09 May 2013

**Subject: State Significant Development Application for a staged mixed use development comprising residential, commercial, retail, community and open space uses at The Haymarket (Concept Proposal) (SSD5878)**

DEVELOPMENT APPLICATION
PARAMETER PLAN 03
MAXIMUM HORIZONTAL BUILDING ENVELOPE

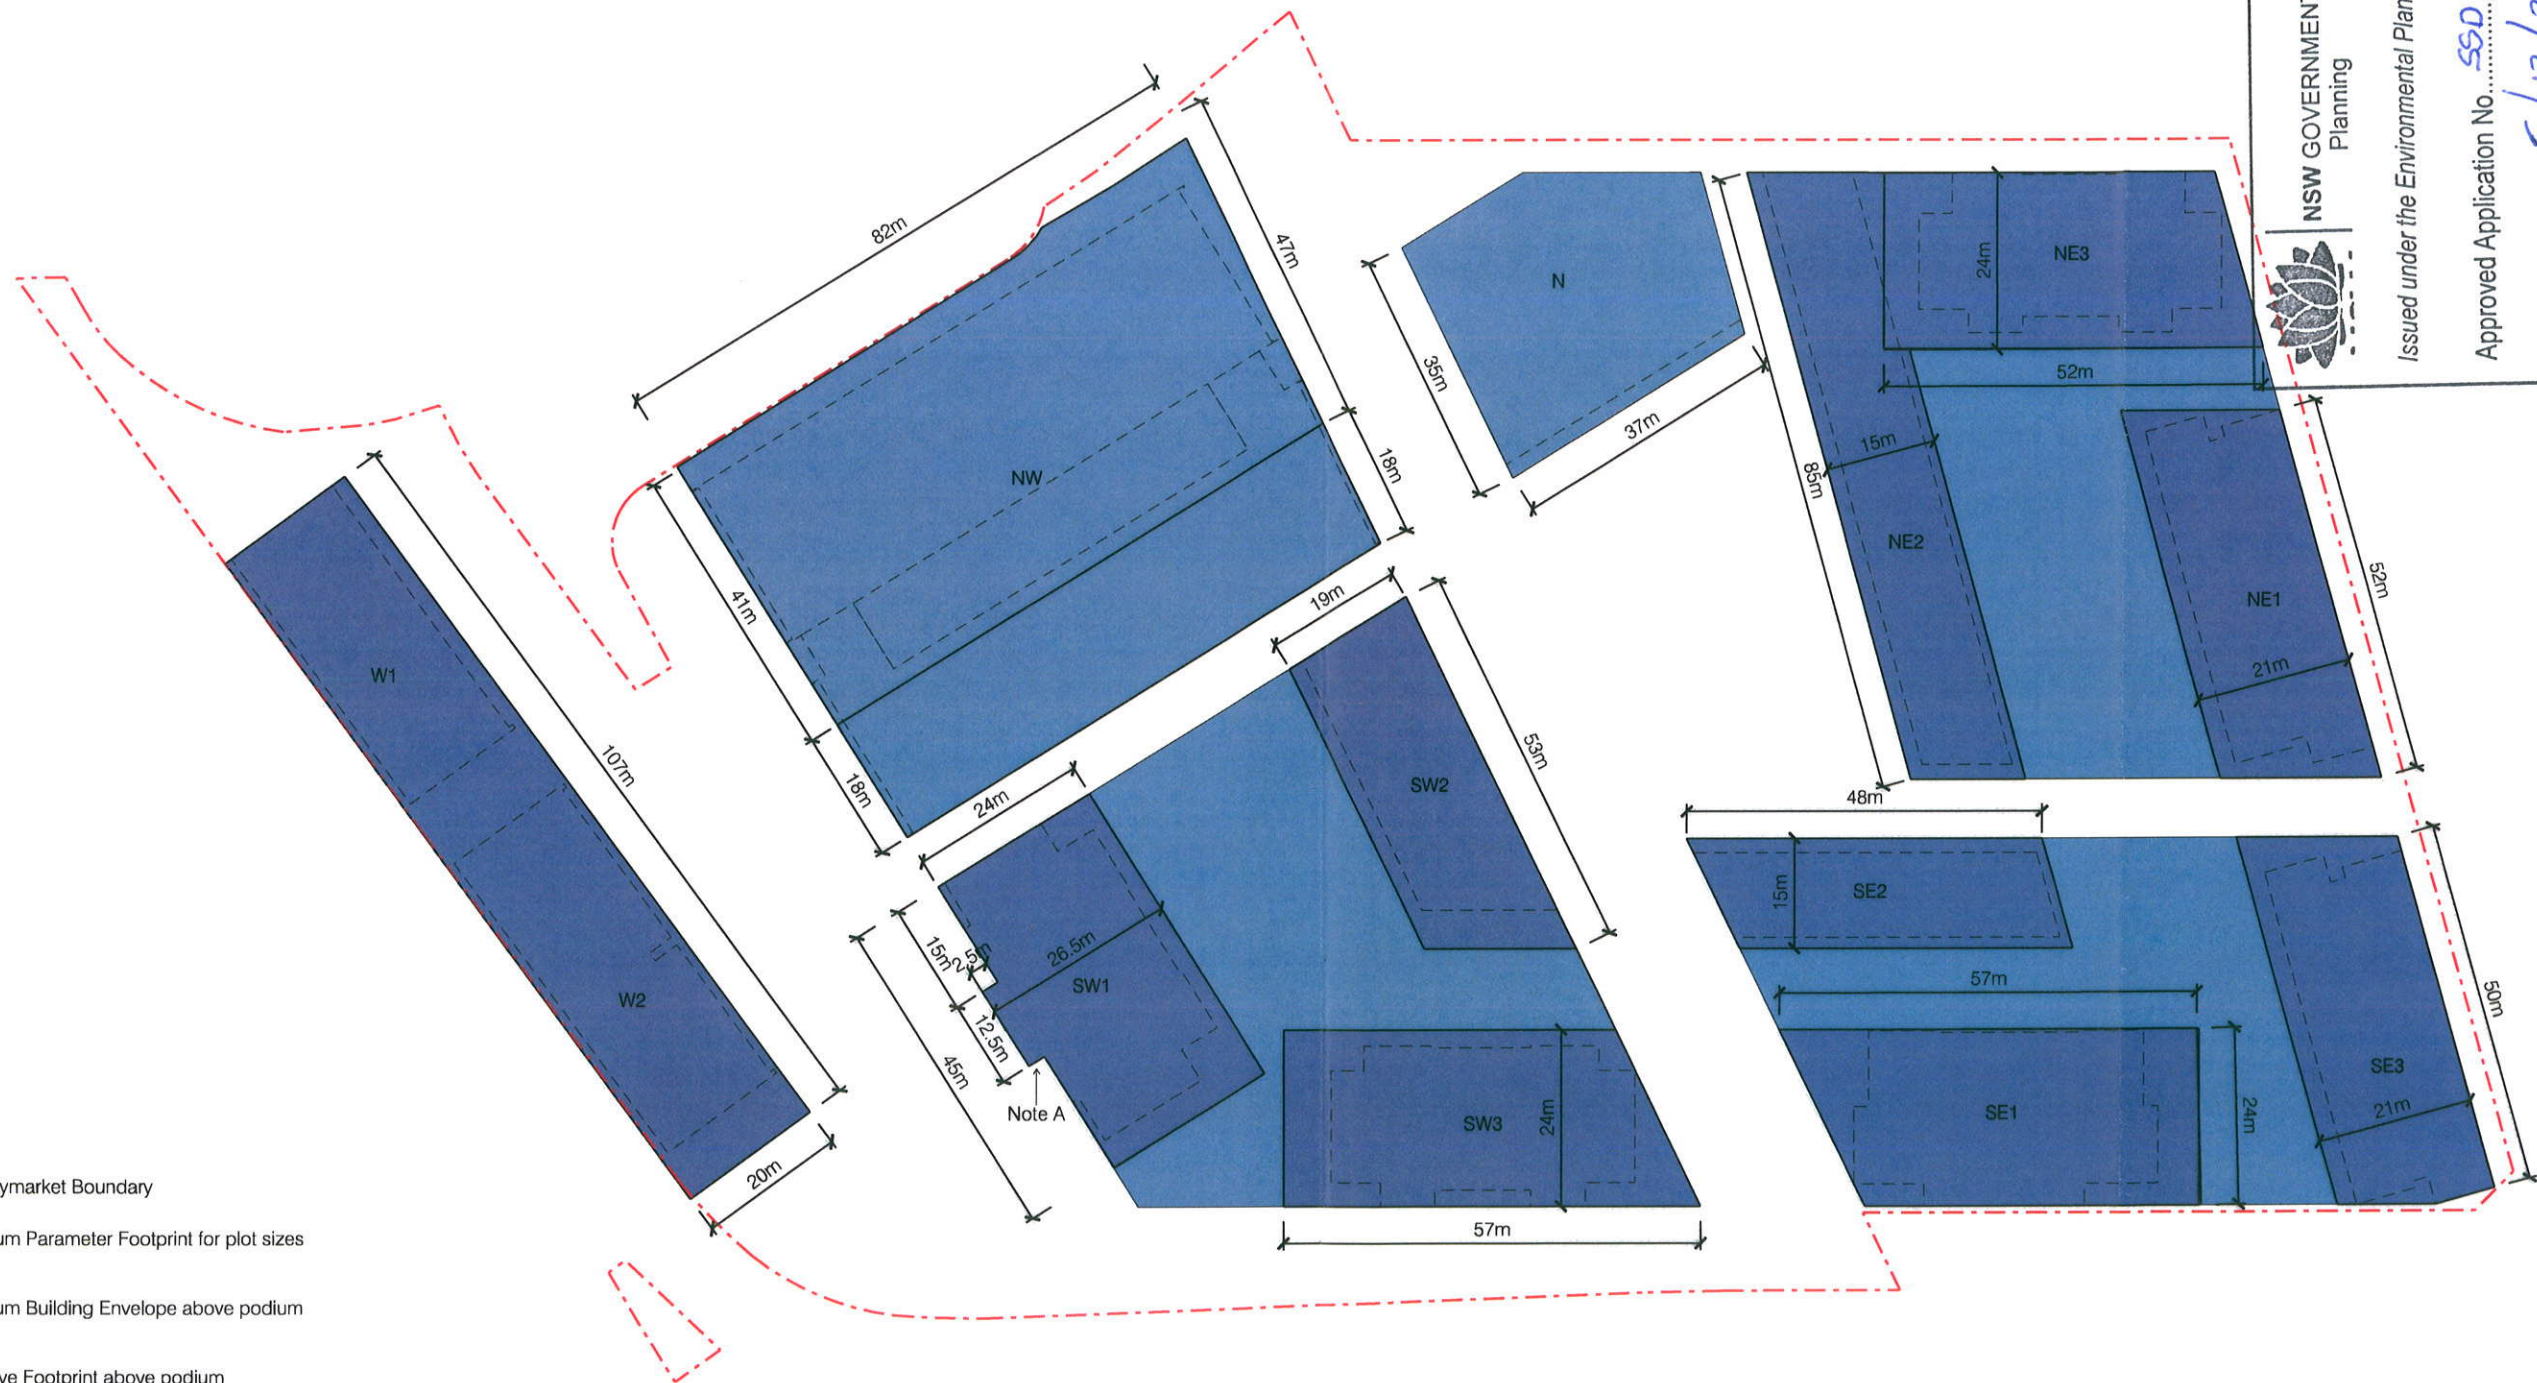
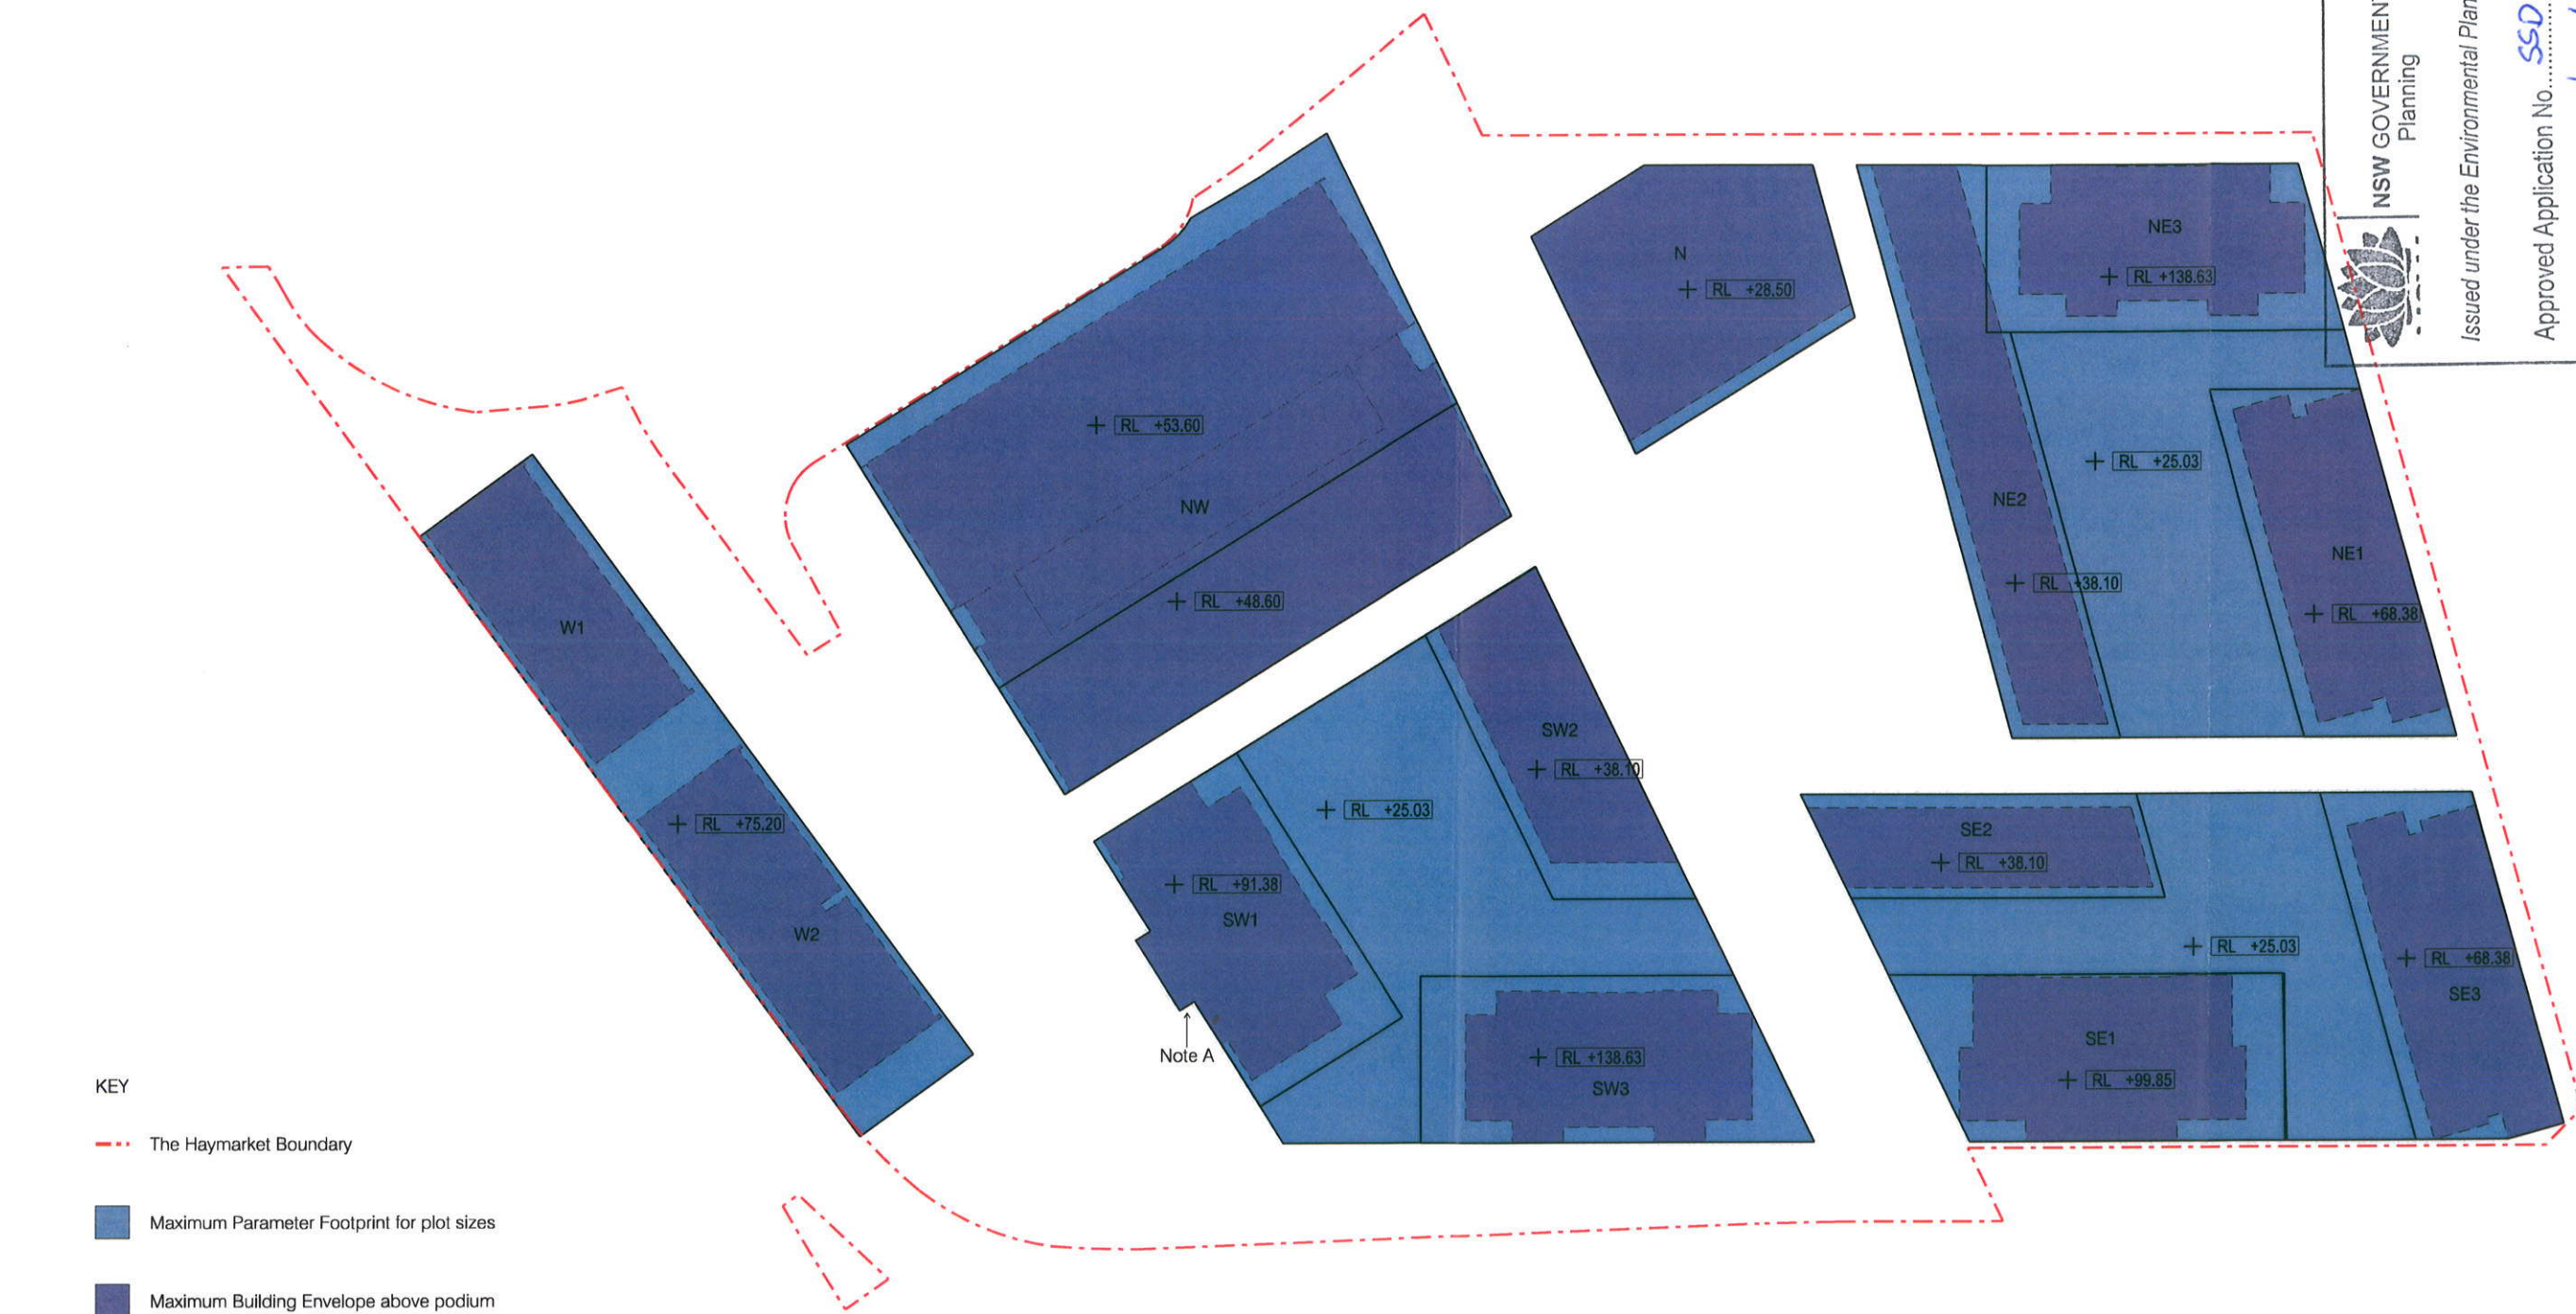
Within the site, there are 14 separations between buildings. Of these 14 separations, the proposed distances in eight are non-compliant. With the proposed separations in those eight, it is impossible to achieve the intent of the Residential Flat Design Code separation guidelines by detailed designs or any other method.

**Of these 14 separations, the proposed distances in 8 are non-compliant.**

<b>Building Names</b>	<b>Height of each Building (floors) Section 4.6.2 Table 7 page 59</b>	<b>Proposed Separation (metres) Figure 48 in Section 5.6.3 on page 87</b>	<b>RFDC control separation (metres)</b>	<b>Comment by this submission</b>
SW1 to NW	25 and 12	8	<ul style="list-style-type: none"> <li>- 24 metres between habitable rooms/balconies</li> <li>- 18 metres between habitable rooms/balconies and non-habitable rooms</li> <li>- 12 metres between non-habitable rooms</li> </ul>	The proposed separation is insufficient for all types of rooms. It is therefore impossible to achieve the intent of the RFDC guidelines by detailed designs or any other method.
N to NE3	6 and 40	8	<ul style="list-style-type: none"> <li>- 18 metres between habitable rooms/balconies</li> <li>- 13 metres between habitable rooms/balconies and non-habitable rooms</li> <li>- 9 metres between non-habitable rooms</li> </ul>	The proposed separation is insufficient for all types of rooms. It is therefore impossible to achieve the intent of the RFDC guidelines by detailed designs or any other method.

SW3 to SW2	40 and 9	9	<ul style="list-style-type: none"> <li>- 24 metres between habitable rooms/balconies</li> <li>- 18 metres between habitable rooms/balconies and non-habitable rooms</li> <li>- 12 metres between non-habitable rooms</li> </ul>	The proposed separation is insufficient for all types of rooms. It is therefore impossible to achieve the intent of the RFDC guidelines by detailed designs or any other method.
SE1 to SE2	28 and 9	9	<ul style="list-style-type: none"> <li>- 24 metres between habitable rooms/balconies</li> <li>- 18 metres between habitable rooms/balconies and non-habitable rooms</li> <li>- 12 metres between non-habitable rooms</li> </ul>	The proposed separation is insufficient for all types of rooms. It is therefore impossible to achieve the intent of the RFDC guidelines by detailed designs or any other method.
W1 to W2	21 and 21	10	<ul style="list-style-type: none"> <li>- 24 metres between habitable rooms/balconies</li> <li>- 18 metres between habitable rooms/balconies and non-habitable rooms</li> <li>- 12 metres between non-habitable rooms</li> </ul>	The proposed separation is insufficient for all types of rooms. It is therefore impossible to achieve the intent of the RFDC guidelines by detailed designs or any other method.

NE1 to NE3	18 and 40	12	<ul style="list-style-type: none"> <li>- 24 metres between habitable rooms/balconies</li> <li>- 18 metres between habitable rooms/balconies and non-habitable rooms</li> <li>- 12 metres between non-habitable rooms</li> </ul>	The proposed separation is sufficient for non-habitable rooms only. It is therefore possible to achieve the intent of the RFDC guidelines only if all rooms are non-habitable.

<b>Building Names</b>	<b>Height of each Building (floors) Section 4.6.2 Table 7 page 59</b>	<b>Proposed Separation (metres) Figure 48 in Section 5.6.3 on page 87</b>	<b>RFDC control separation (metres)</b>	<b>Comment by this submission</b>
SE1 to SE3	28 and 18	18	- 24 metres between habitable rooms/balconies - 18 metres between habitable rooms/balconies and non-habitable rooms - 12 metres between non-habitable rooms	The proposed separation is sufficient only if there are no habitable rooms/balconies on the exterior of both buildings.
SW1 to SW3	25 and 40	18	- 24 metres between habitable rooms/balconies - 18 metres between habitable rooms/balconies and non-habitable rooms - 12 metres between non-habitable rooms	The proposed separation is sufficient only if there are no habitable rooms/balconies on the exterior of both buildings.
Unspecified building on NE plot to Holiday Inn at 68 Harbour St	Over 12 and 12	EIS states that separation is non-compliant on floors 9 to 12 (page 88), but does not state the proposed separation	- 24 metres between habitable rooms/balconies - 18 metres between habitable rooms/balconies and non-habitable rooms - 12 metres between non-habitable rooms	Cannot comment. EIS needs to show the proposed separation.
